Our ref: PA01117145

25 September 2020

### Pre-application Advice

#### STANLEY HOUSE HOTEL, MELLOR, LANCASHIRE

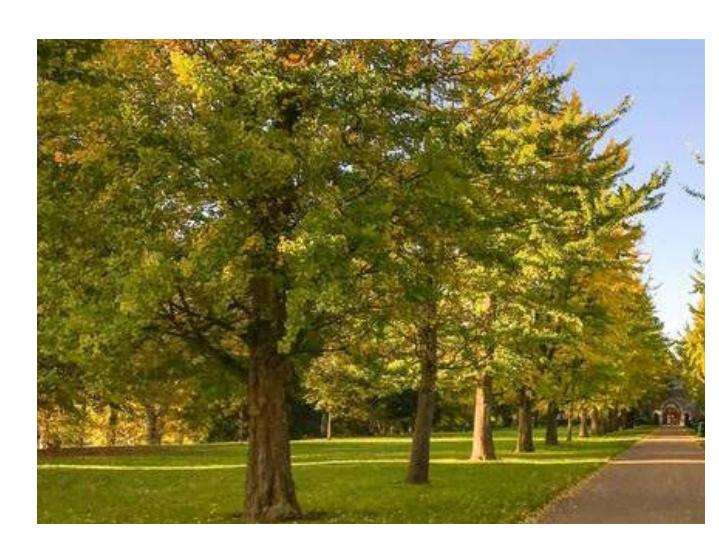
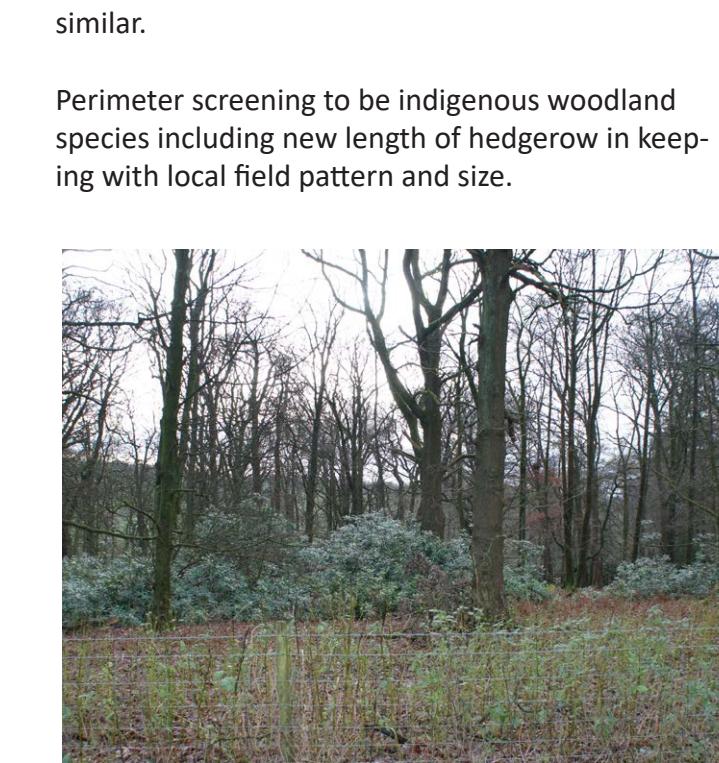
The revised proposals have also given consideration to the wider hard and soft landscaping masterplan for the site, most notably in relation to the parking provision. While this would still be a large and intrusive element of the site plan, it is noted the revised layout does break it up to a greater extent than the previously approved scheme. This is positive, as the unbroken nature of the currently approved configuration will exaggerate its size, and create the sense of an encircling mass. It is also positive to note that the applicant proposes to use alternative surface finishes in some areas of the car parking provision, in order to create a softer visual appearance.

To the west of the site, the applicant seeks to create a more formal area of garden between one of the barns and the proposed new banqueting building. This is not inherently objectionable, and it is understood how this area would support the functioning of the banqueting building. However, care should be taken to ensure that the building and formal garden read as a modern creation, and do not create a historically inauthentic suggestion that the site previously had a walled garden or a more formal landscaped setting. This could be achieved by ensuring that the new banqueting building is of a high quality but modern design, and possibly through the introduction of small plaque on the banqueting building noting the date of construction of the building and garden.
